CITY OF ALBUQUERQUE

July 1, 2019

Re: JIFFY LUBE
8305 Menaul Blvd. NE
Traffic Circulation Layout
Engineer's/Architect's Stamp **6-24-2019** (H19D086)

ENGINEER'S SEAL	ENGINEER: JIFFY LUBE	DRAWN BY: BF
		8305 MENAUL BLVD. NE	DATE: 11/6/2019
		TRAFFIC CIRCULATION LAYOUT PLAN	2018016_TLC
		TIERRA WEST, LLC 5571 MIDWAY PARK PLACE NE ALBUQUERQUE, NM 87109 (505) 858-3100 www.tierrawestllc.com	SHEET # C1 JOB # 2018016

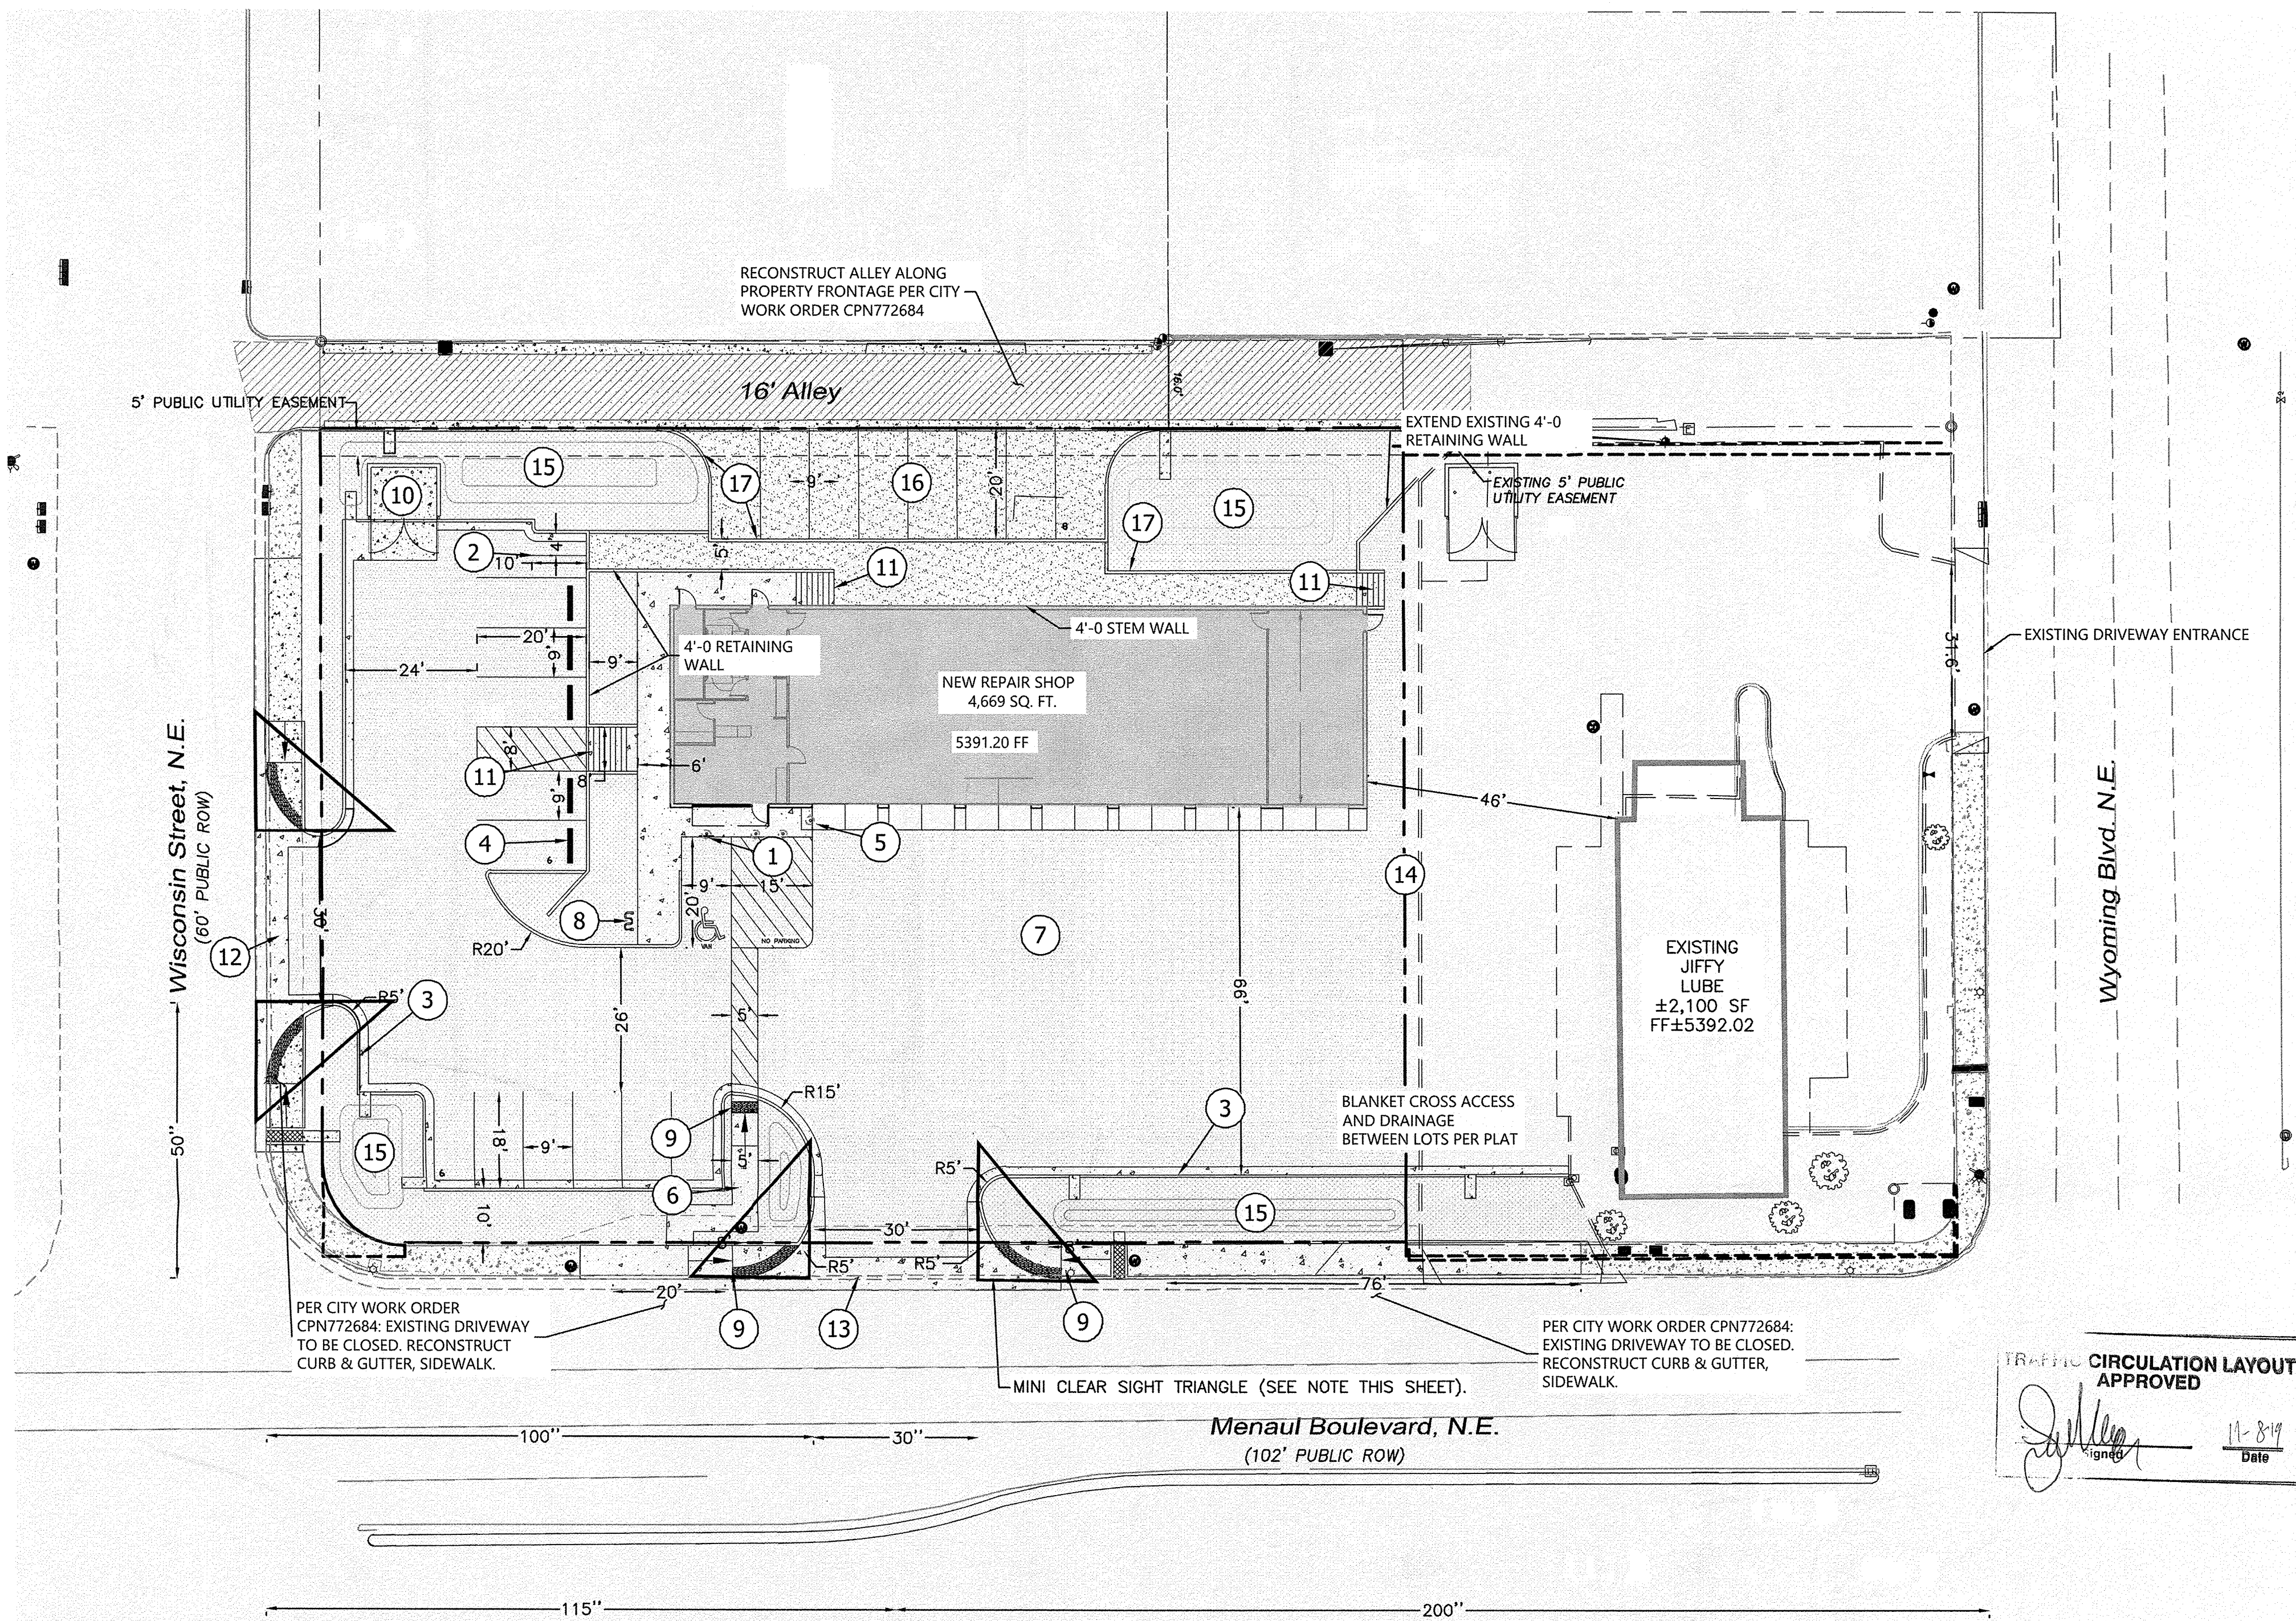
1. Parking spaces located on th North side of the property does not have dimensions.
2. provide a copy of refuse approval.
3. Only one drive-pad is allowed on Wisconsin St.
4. TCL cannot be approved before the lot line elimination process.
